Engineers Comments Regarding Surface Water Drainage

Application Reference:	WA/51/26/RES	Reviewer Reference:	ADC/EXT5/AF
Planning Officer:	Simon Davis	Date of Review:	27/07/2026
Site Name:	Land East of Wandleys Lane Fontwell		
Application Description:	Approval of reserved matters following the grant of outline planning permission WA/35/23/OUT, for the construction of 95 No. new homes, access, new pedestrian and cycle links, open space, landscaping, habitat creation, drainage features and associated groundworks and infrastructure, including details relating to the Sensitive Lighting Strategy, POS details and Part M Compliance. This application is in CIL Zone 3 and is CIL Liable as new dwellings.		
Assessment Number:	1

Drawing Title
EXCEEDANCE FLOW ROUTES
SHEET 1 OF 2

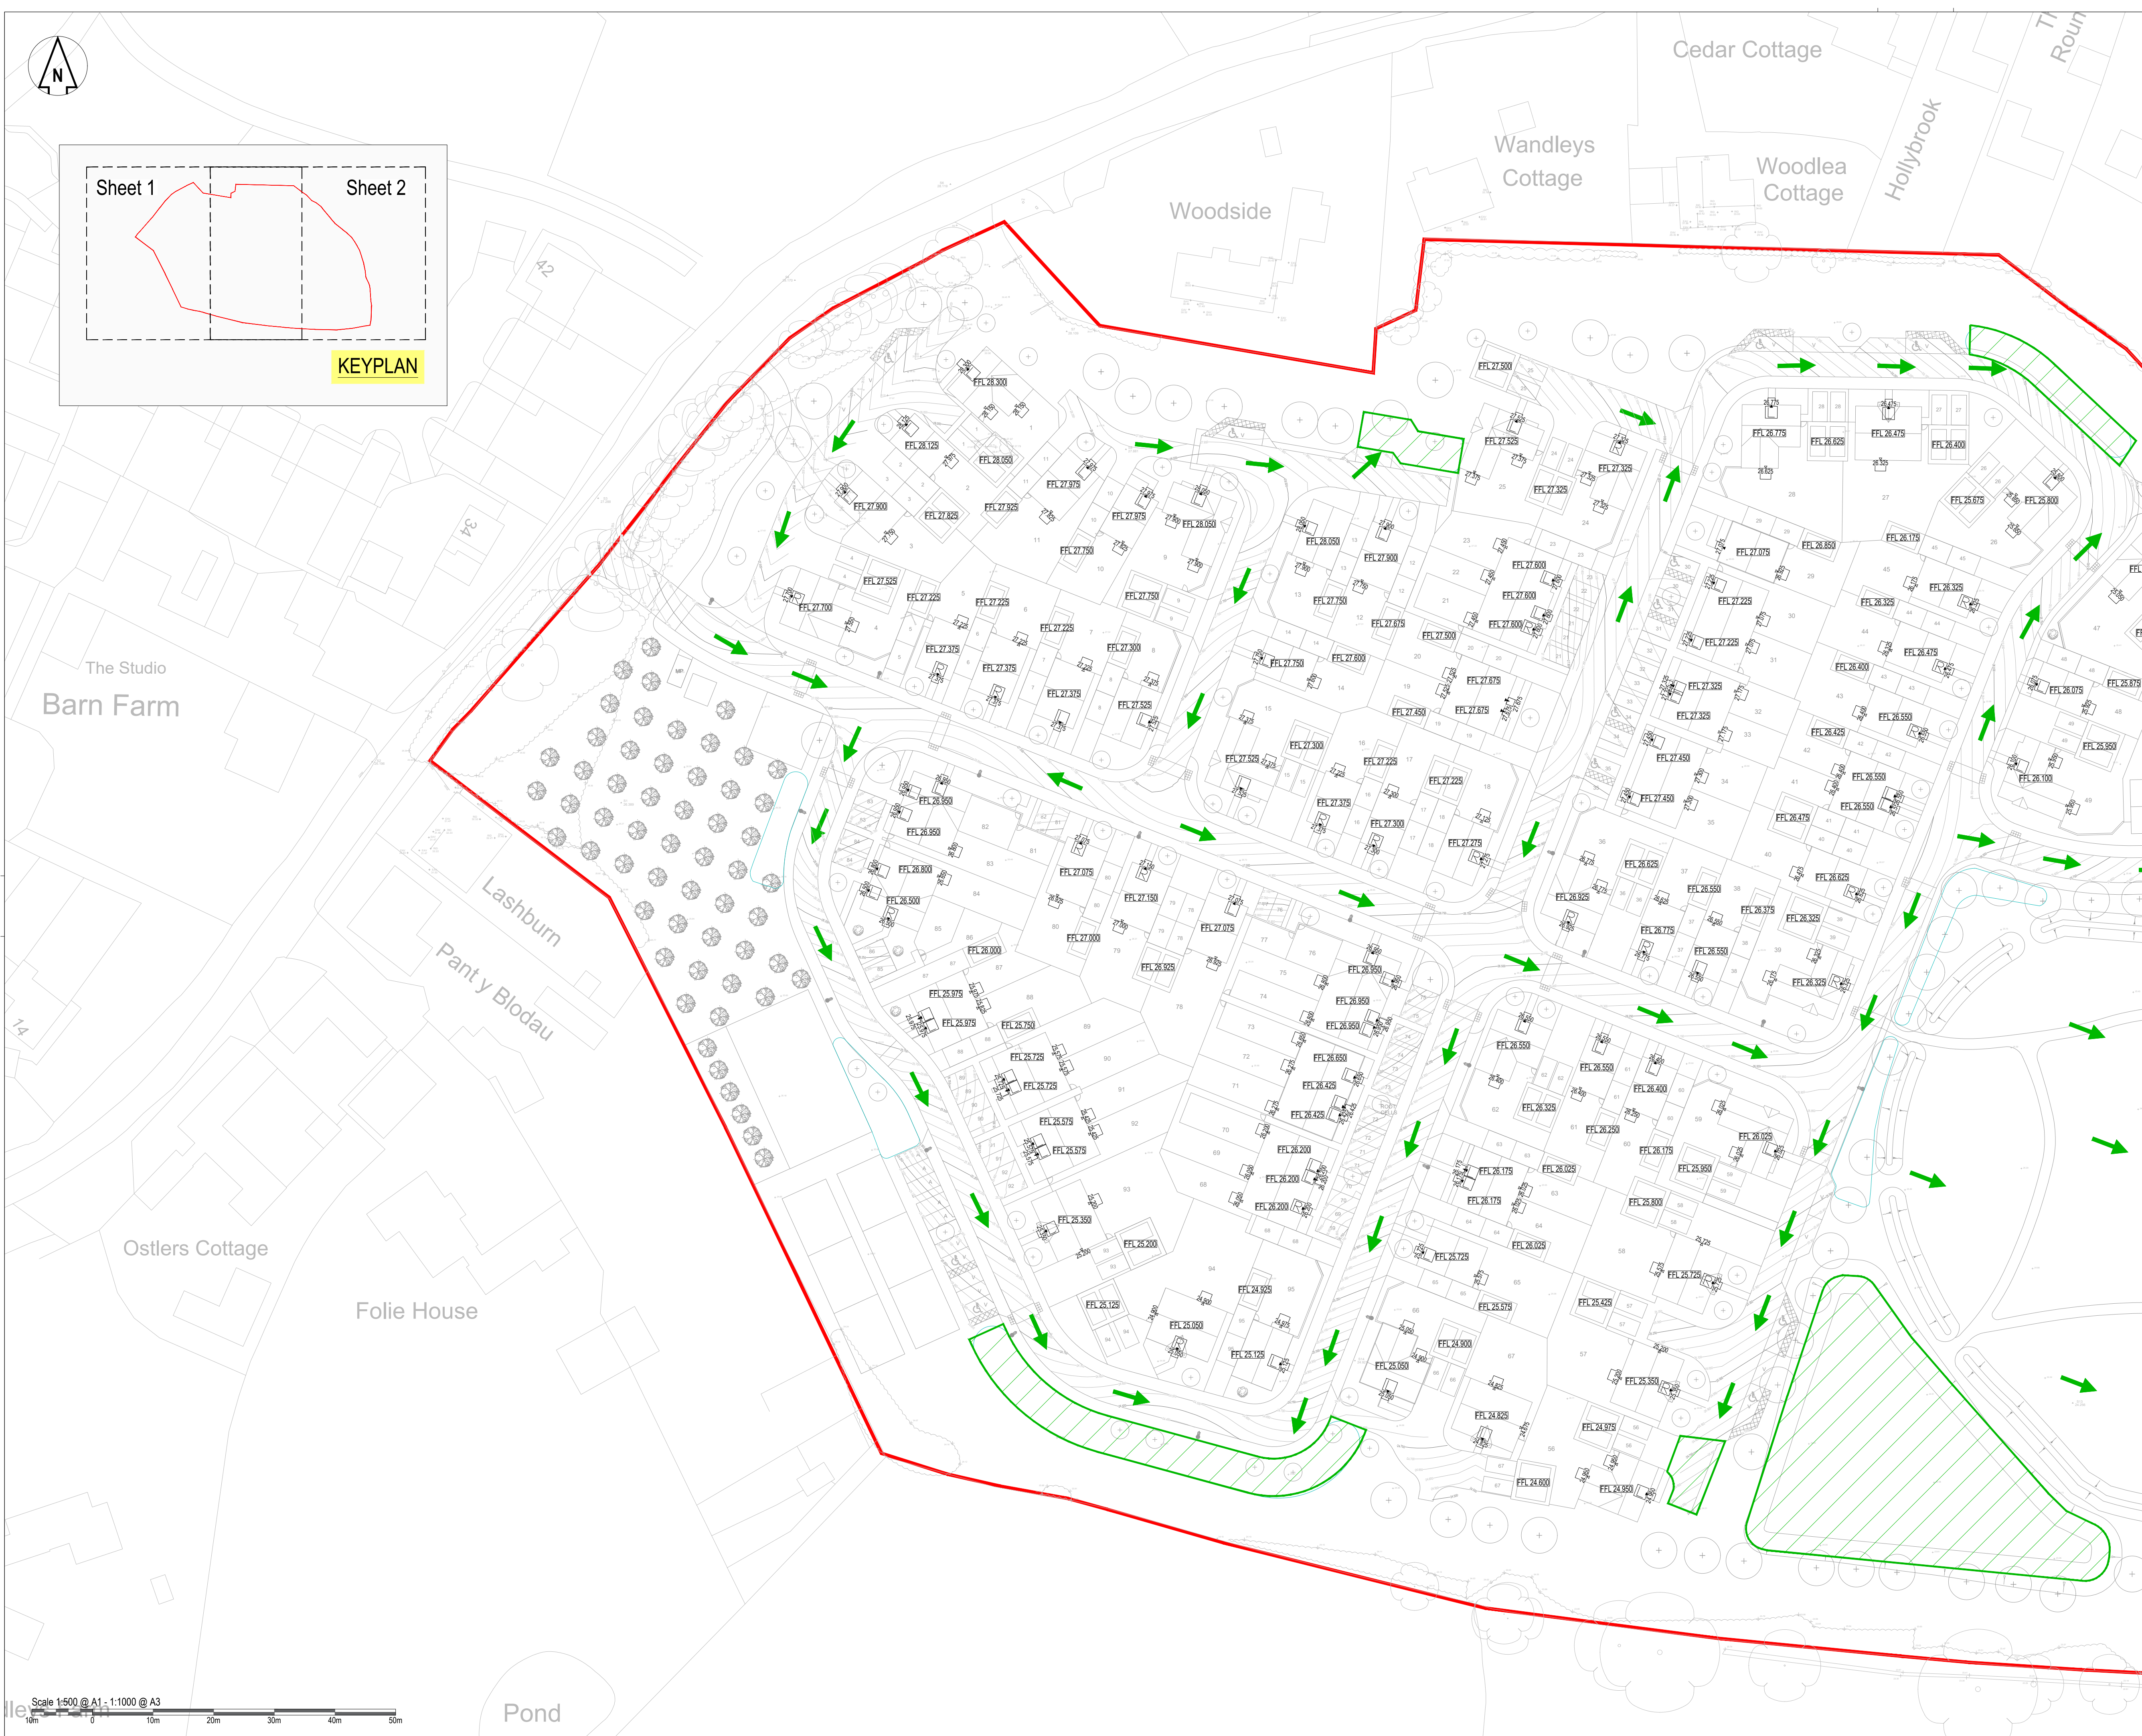
3.5. An exceedance path appears to flow towards the Foul Water Pumping Station. Please clarify the levels are designed to divert the flow away from the pumping station compound.
